Date: 12 June 2018
Our ref: 14714/03/SSL/16039700v1
Your ref: BE/40/18/PL

New Barn Lane: Application for new access from New Barn Lane to Land West of New Barn Lane & relocation of 5 no. existing parking spaces

We write on behalf of our client, The Church Commissioners for England. We have considered the objection made by Bersted Parish Council on the above application.

Proposed Access to New Barn Lane

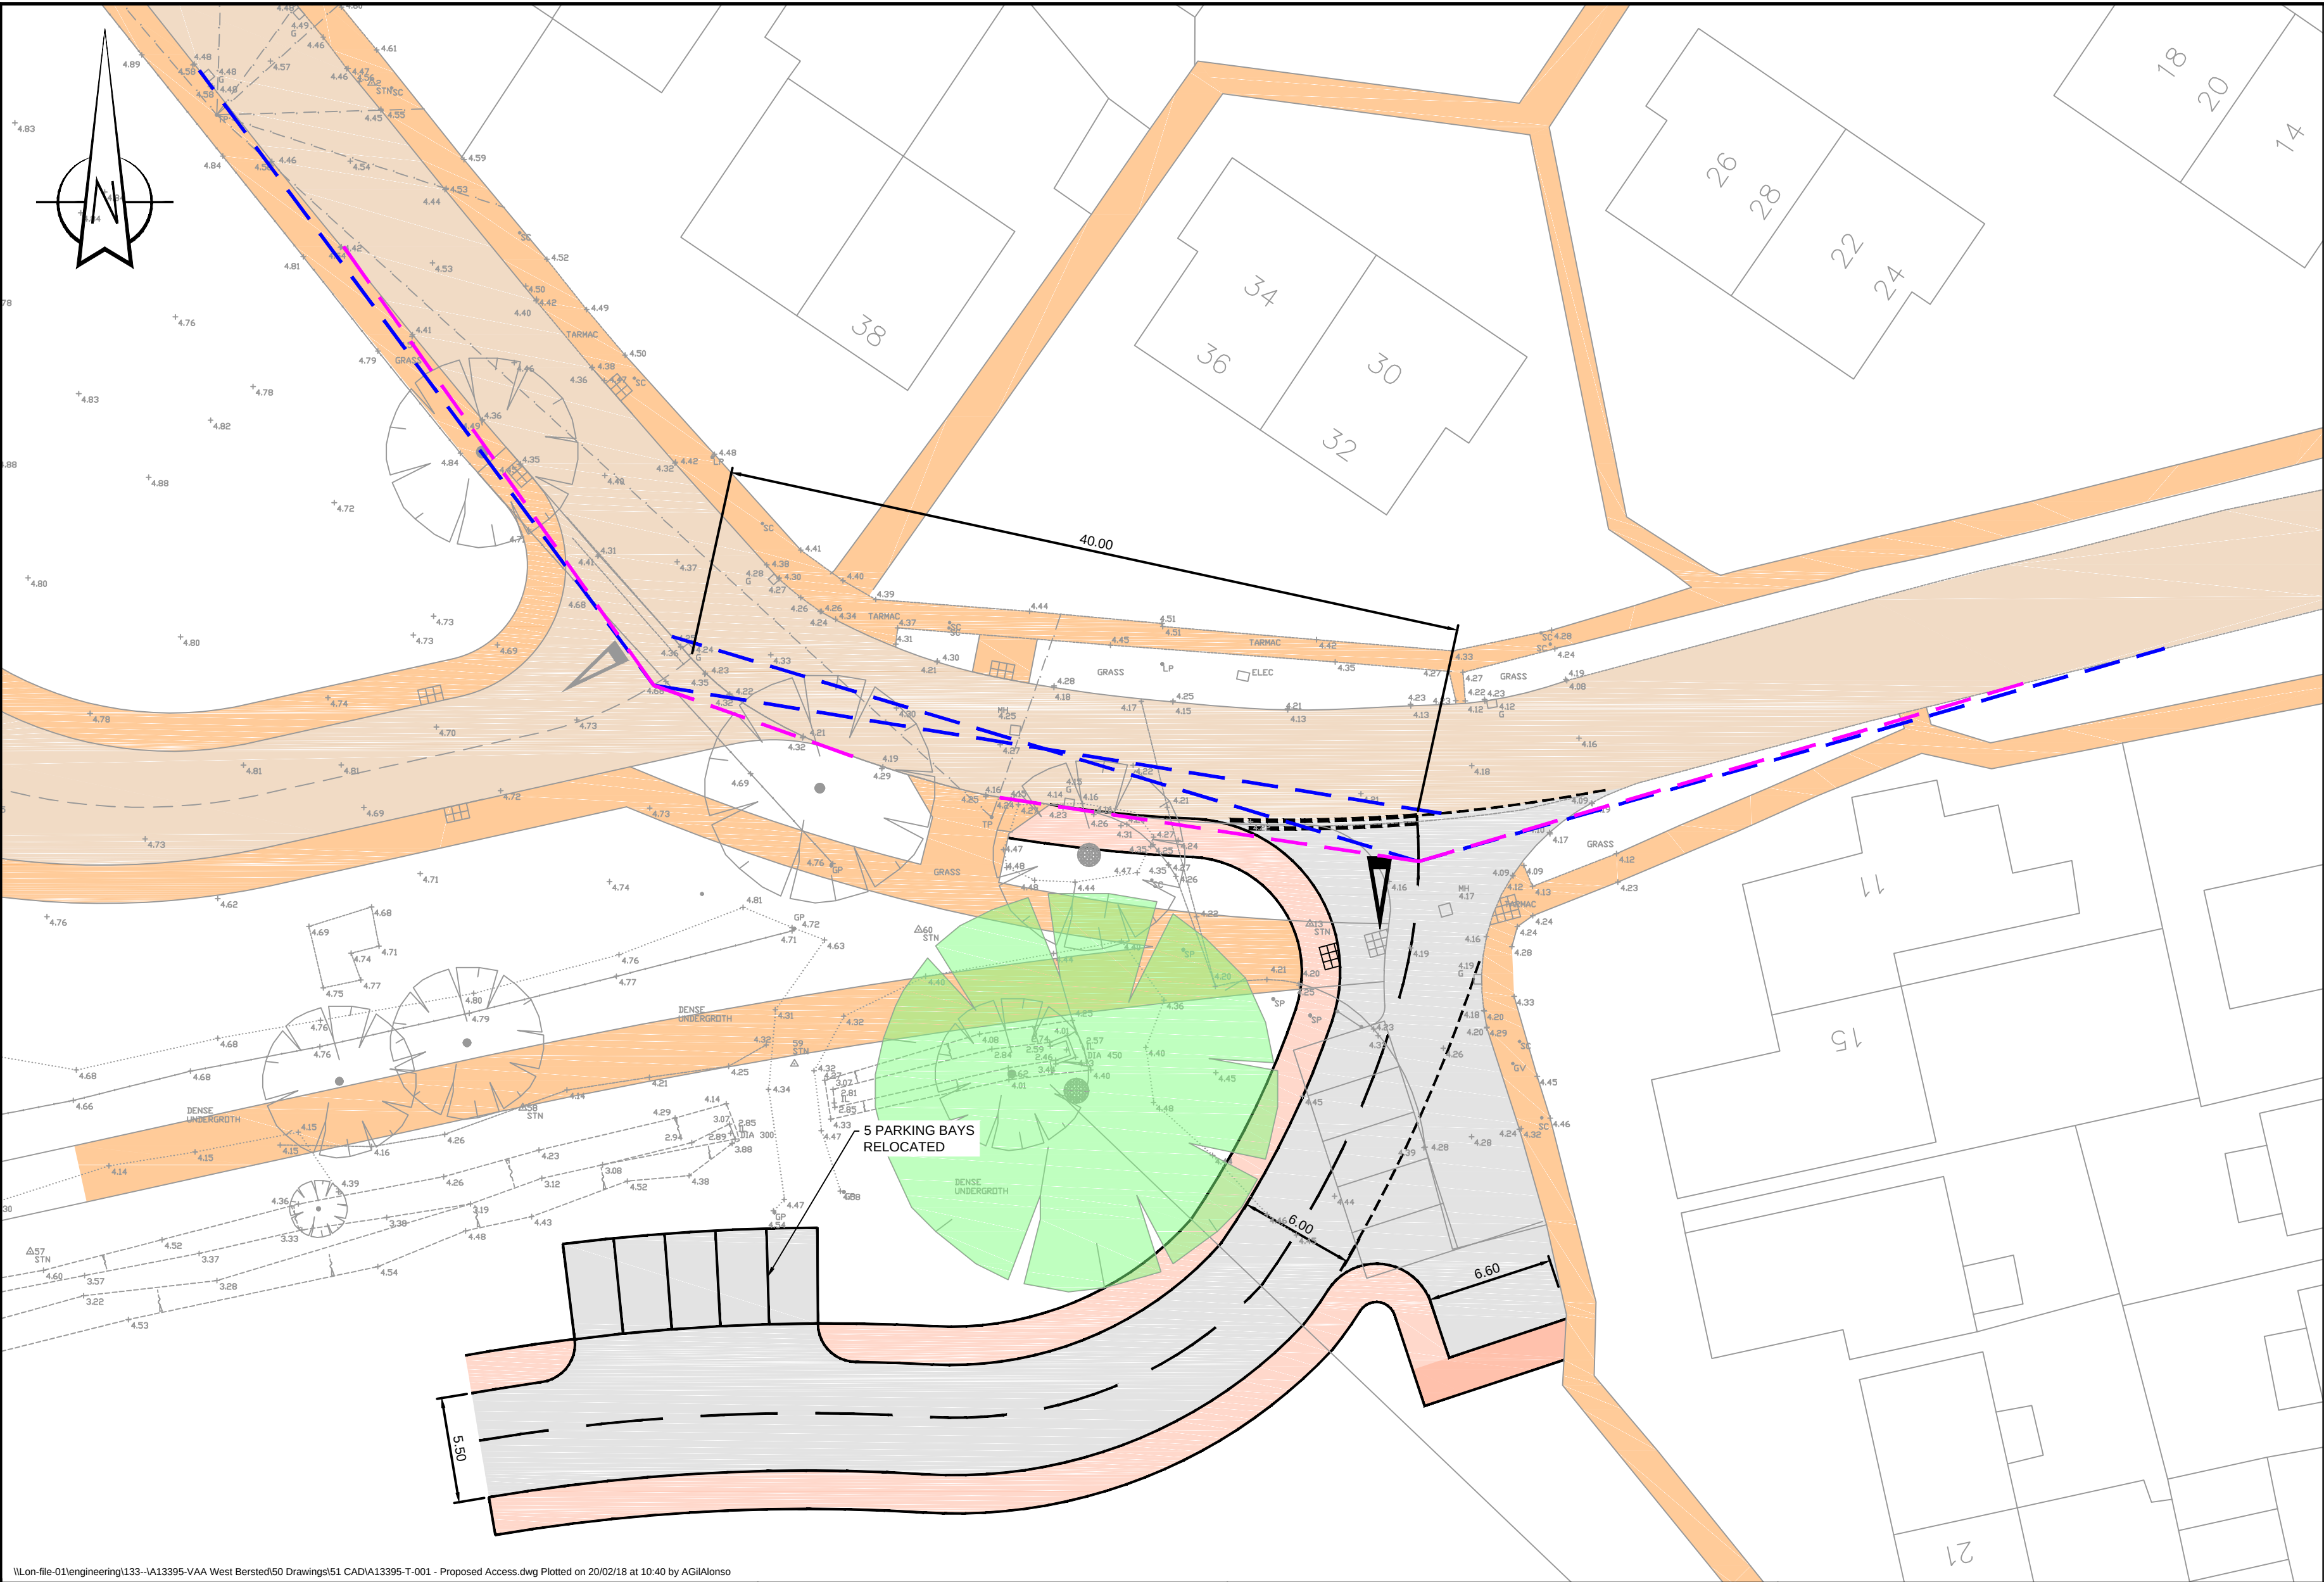
"The proposed new entrance is unneighbourly to the bungalows (11, 21 New Barn lane) directly in front of the access"

"Loss of parking for those bungalows 19 21 New Barn lane, removal of the 5 spaces to a new location inside the development does not guarantee that they will get use of them and is contrary to Bersted Neighbourhood Development plan policy HDQ8 for accessible car parking."

“Highway safety and traffic, as bungalows 11 to 17 have driveways that are in direct line with the proposed access which may cause safety issues.”

The Transport Assessment produced by Pell Frischmann shows that there is expected to be a light level of traffic using this access road. The trip generation from the consented 50-unit development that the proposed access will serve, is expected to be less than one vehicle movement per every two minutes in the weekday AM and PM peak hours. Outside of the peak hours, the traffic generation from the consented development is estimated to be one vehicle movement every 3.3 minutes (9-5pm). The layout and location of the road is appropriate for its context and has been agreed with WSCC Highways following a pre-application submission.

In the Highways Authority comment on the application, the re-provision of the parking spaces was considered, and wasn't deemed to cause reason to refuse the application:

“The provision of the 5 car parking spaces along the site access does not guarantee the use of these spaces to existing residents, however given the level of on-street car parking availability in this area this is not considered to warrant a reason to refuse the application”.

The Transport Statement that was provided in support of the planning application demonstrated that highway safety would not be an issue with this proposed development. The proposed site access arrangements were tested in terms of swept path analysis. It was demonstrated that the proposed junction will provide adequate visibility splays in accordance with the appropriate DfT/DCLG Manual for Streets standards. In addition to this, a Stage 1 Road Safety Audit (RSA) was carried out. The Stage 1 RSA concluded that there were no issues with the proposed design, although it did note that the revised location of a telegraph pole should be provided at the detailed design stage. This comment was accepted.

WSCC as Highways Authority were consulted on this application. They have considered the proposals and the associated Transport Statement, and have no objections to the proposed access arrangements.
